The Planning Inspectorate  
National Infrastructure Planning  
Temple Quay House  
2 The Square  
Bristol  
BS1 6PN

PINS Reference EN010137 Mona Offshore Wind Farm  
Interested Party numbers MNOW-S57019 & MNOW-S57018

## **Deadline 5 Response 3<sup>rd</sup> December 2024**

Figure 1.19: Daytime construction noise impact magnitudes: Substation groundworks

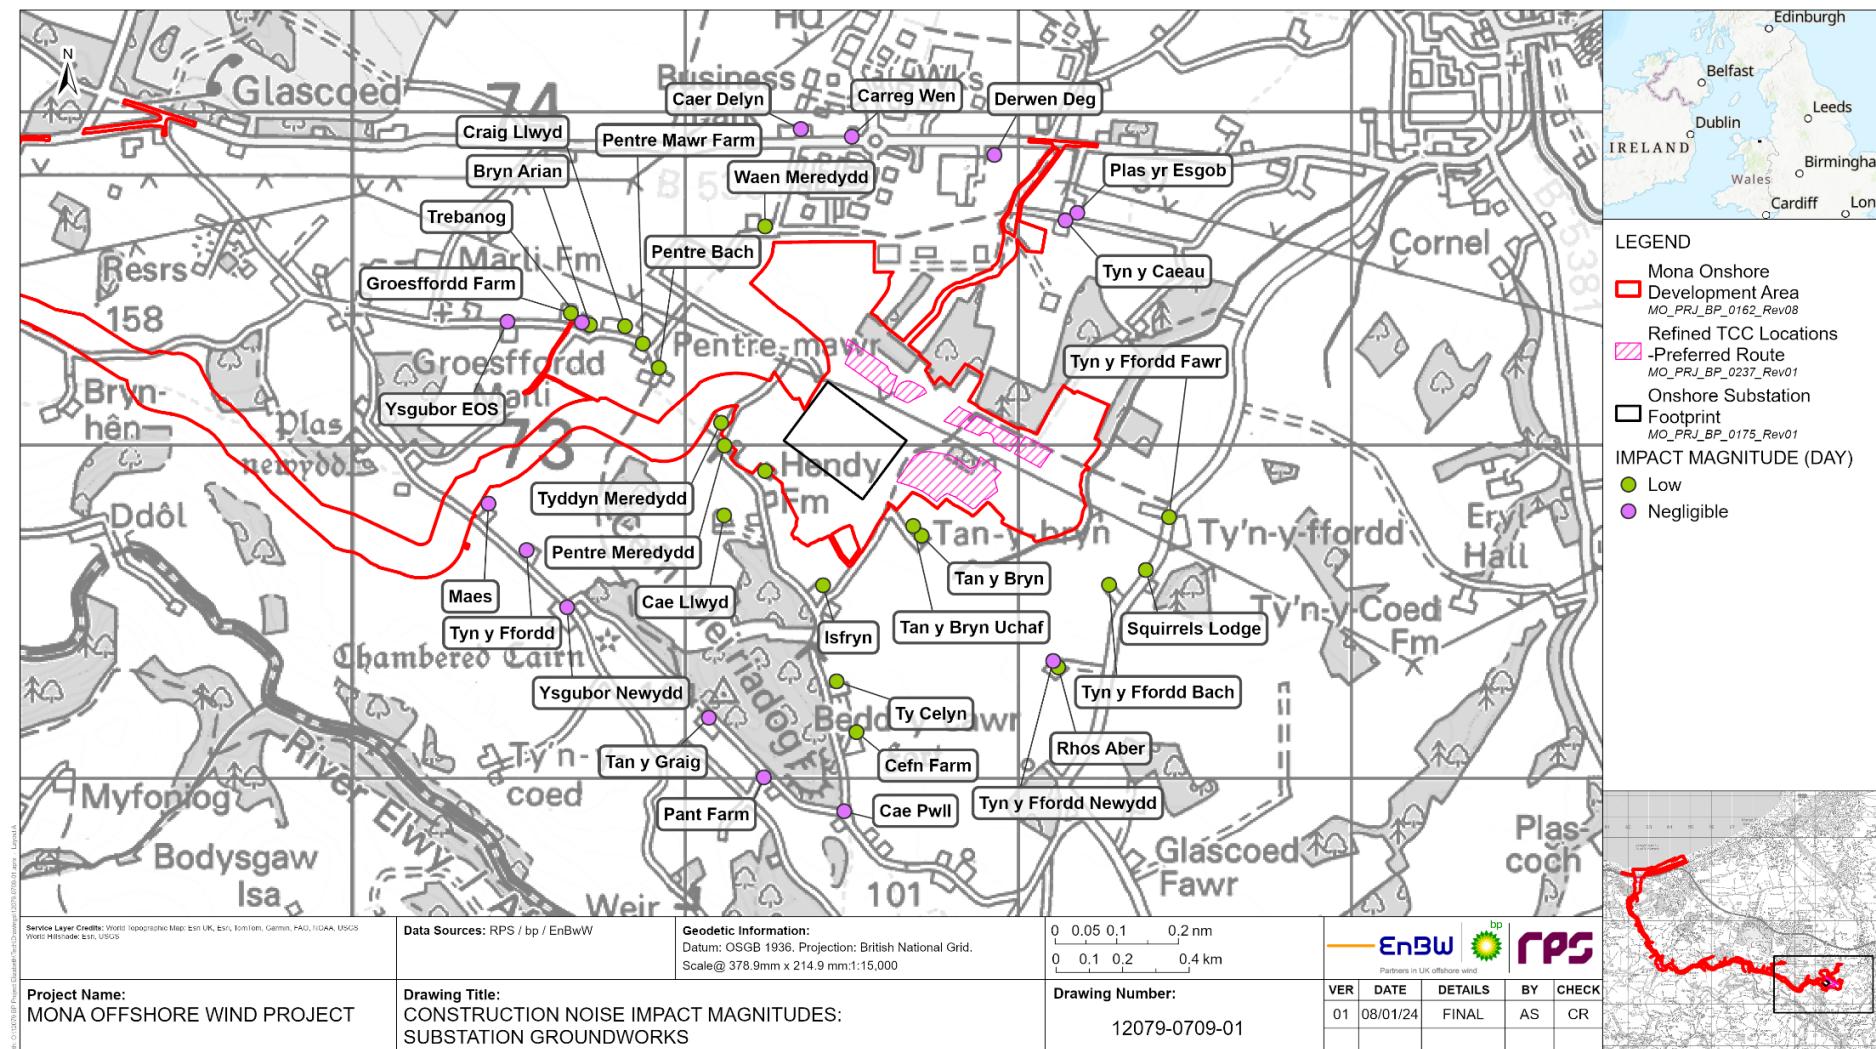
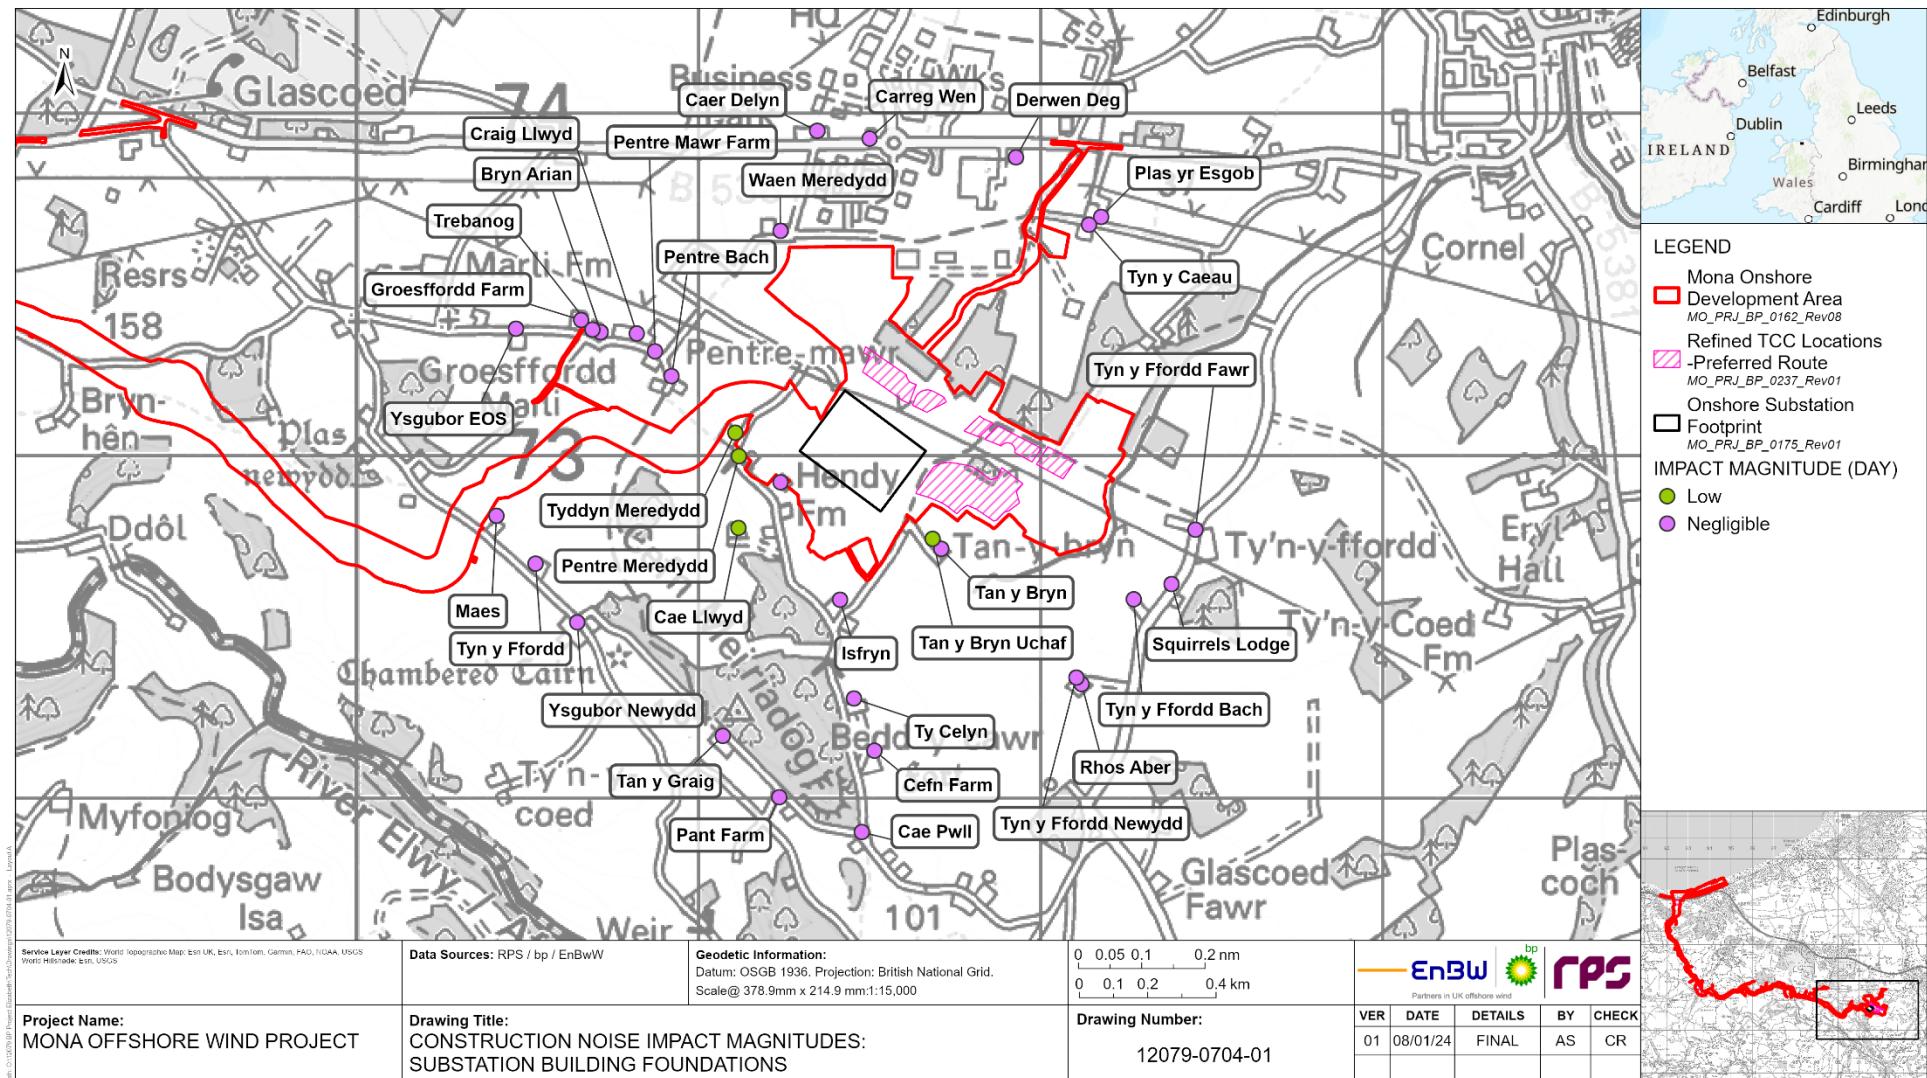
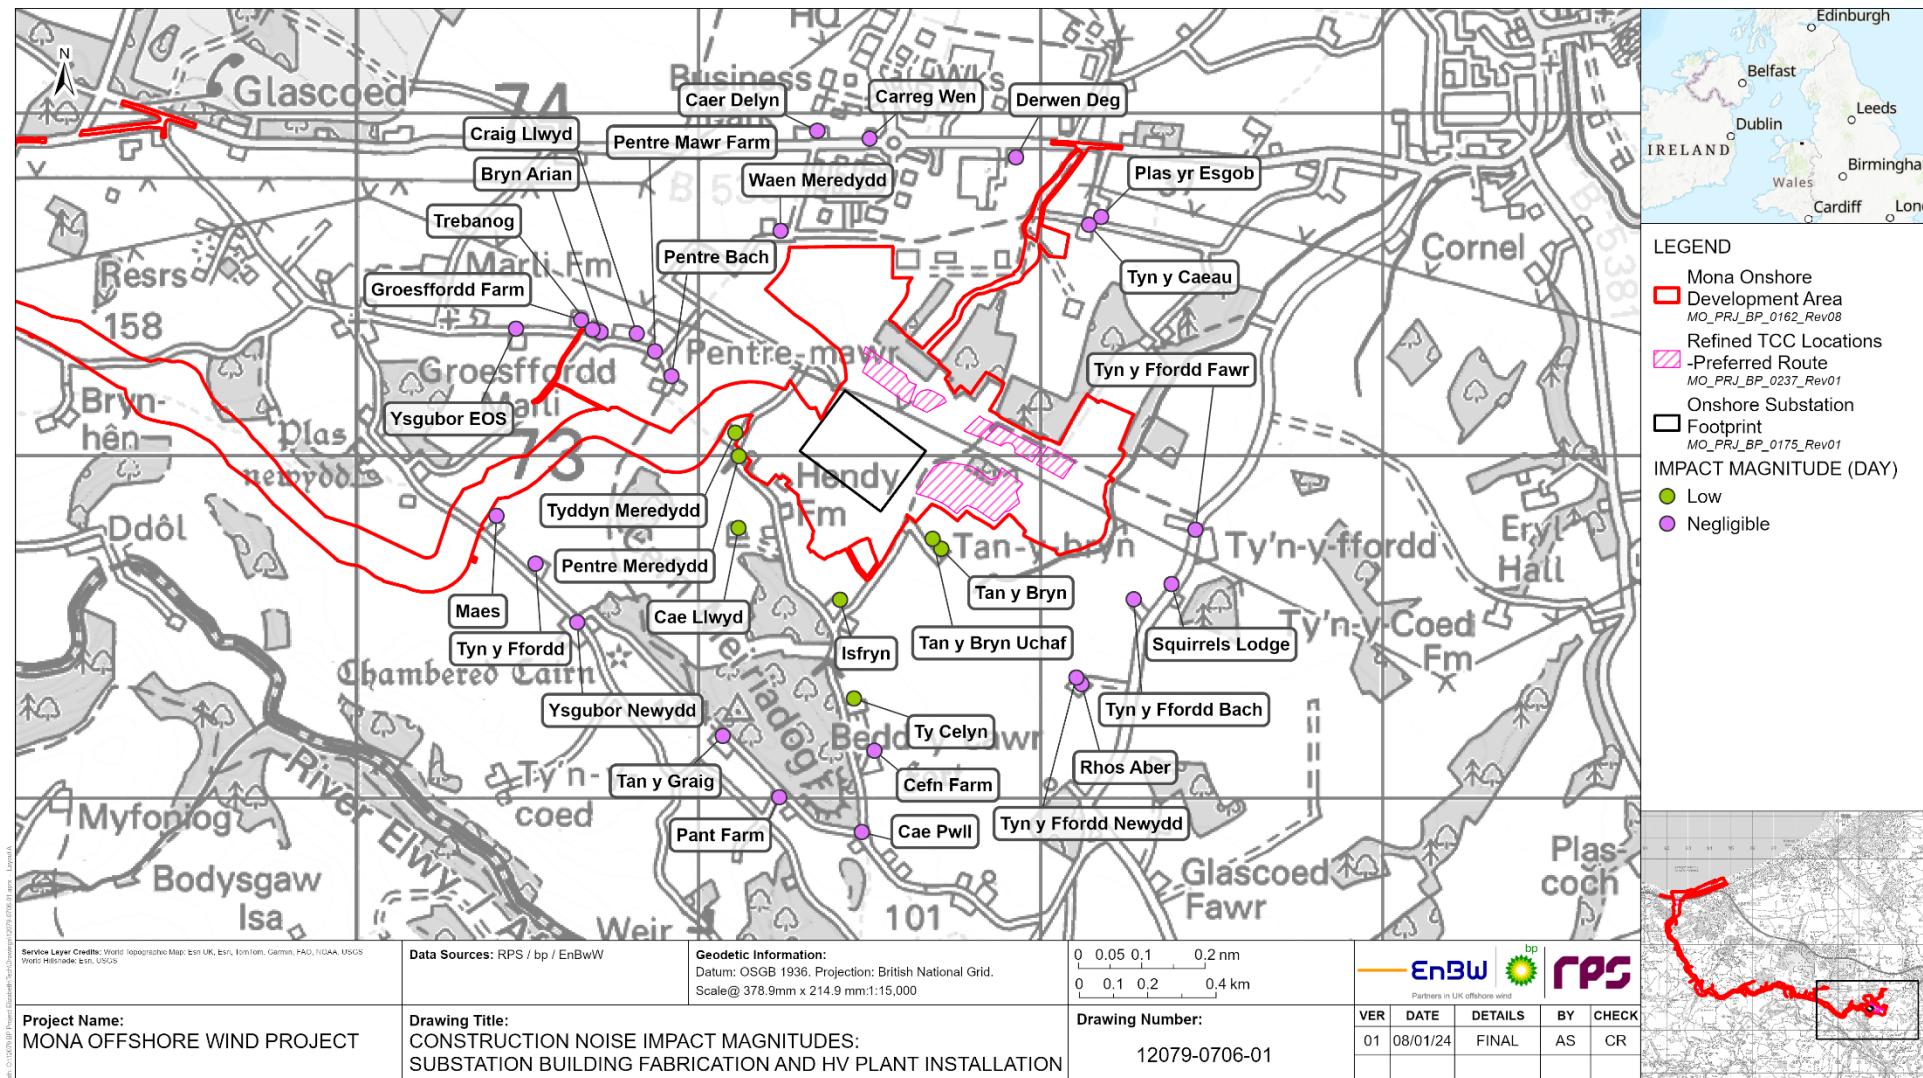
Apart from the pumps for joint bays to which the applicant has downgraded due to it being unlikely. Periods of 24 hour workings are highly likely at the substation site, including concrete pours, generators, pumps, site security etc. . Yet no 24hour construction activities have been modelled for ourselves or nearby properties to the substation and again demonstrates a lack of worst case scenario assessment.

Base Levels 43dB Daytime and 42dB evenings and weekends			
Activity	Overall Noise Level	Change	Impact
TJB and Joint bay excavation	51dB	+8dB day +9dB eve	Medium
TJB and Joint bay construction	54dB	+11dB day +12dB eve	High
Substation Ground works Substation Foundations Substation Fabrication	53dB	+10dB day +11dB eve	High

Of particular note is that for each of the Substation activities, even in isolation and without any other concurrent or cumulative activity, is that they are of High impact and that the activities will go on daily, 6 days a week for period of approximately 4 years. It is also worth reiterating that these are averages throughout the day and evening and so there will be likely extended , prolonged periods of very loud and intrusive impacts.
